From: Rachel Alderson <Rachel.Alderson@arun.gov.uk>
Sent: 28 September 2020 14:35
To: Planning.Responses <Planning.Responses@arun.gov.uk>
Cc: Simon Davis <Simon.Davis@arun.gov.uk>; Sue Howell <Sue.Howell@arun.gov.uk>
Subject: RE: Planning Consultation on: BR/190/20/OUT

Application ref: BR/190/20/OUT

Description: Outline application with all matters reserved for 10 No. new dwellings consisting of 1 No. 1 bed property, 8 No. 2 bed properties & 1 No. 4 bed property with associated services, landscaping, car parking & amenity (resubmission following BR/49/19/OUT).

Location: 26 Burnham Avenue Bognor Regis PO21 2JU

SITE PLAN (PROPOSED) 1:200

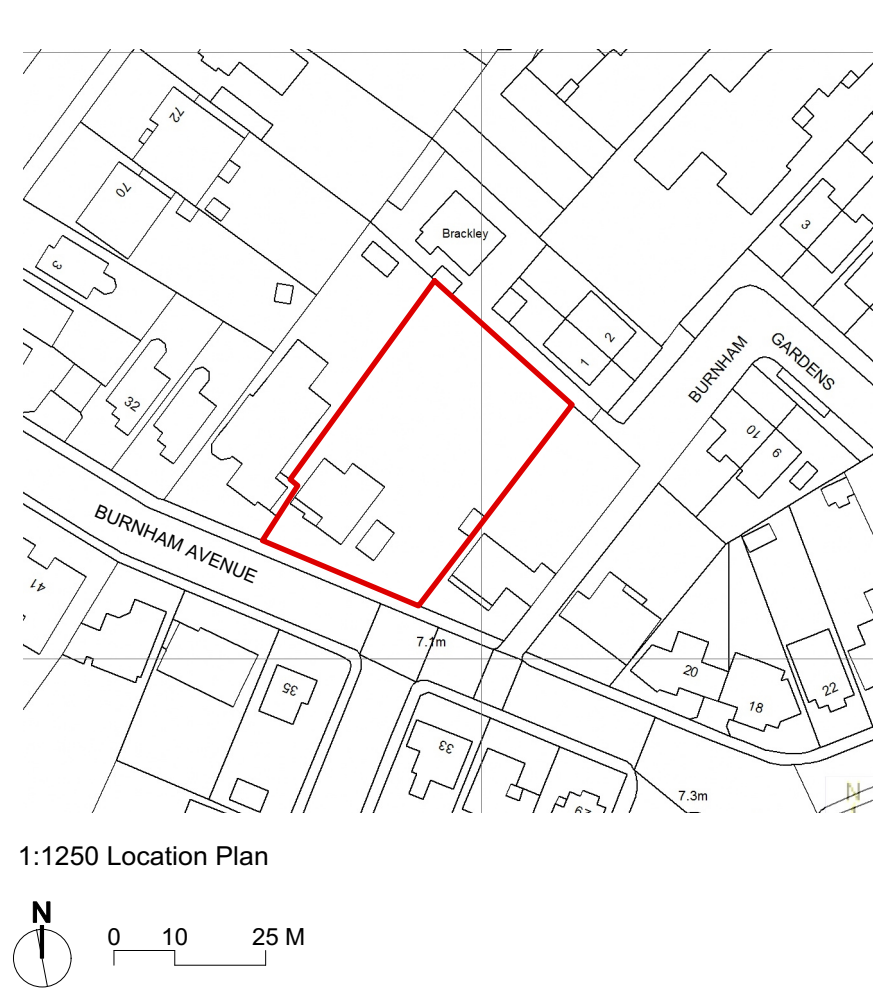
There would be considerable effect on the street scene with these proposals. The proposals indicate that some removal of greening to the frontage would be required for the development. The proposals show the retention of established trees within the rear of the property, these would require protection during construction if they are to remain undamaged. Any tree removals would need to be in consultation with Arun District Councils Tree Officer.

The existing trees in particular along the boundaries and to the north/east of the proposals provide potential valuable screening and could be compromised by these proposals. Root protection Areas (RPA) should extend into the development site and to those in neighbouring land. Before construction, a tree protection scheme must be in place for any adjacent trees whose root protection areas fall within the construction zone from neighbouring land. This should be in accordance with BS 5837:2012 'Trees in relation to construction'
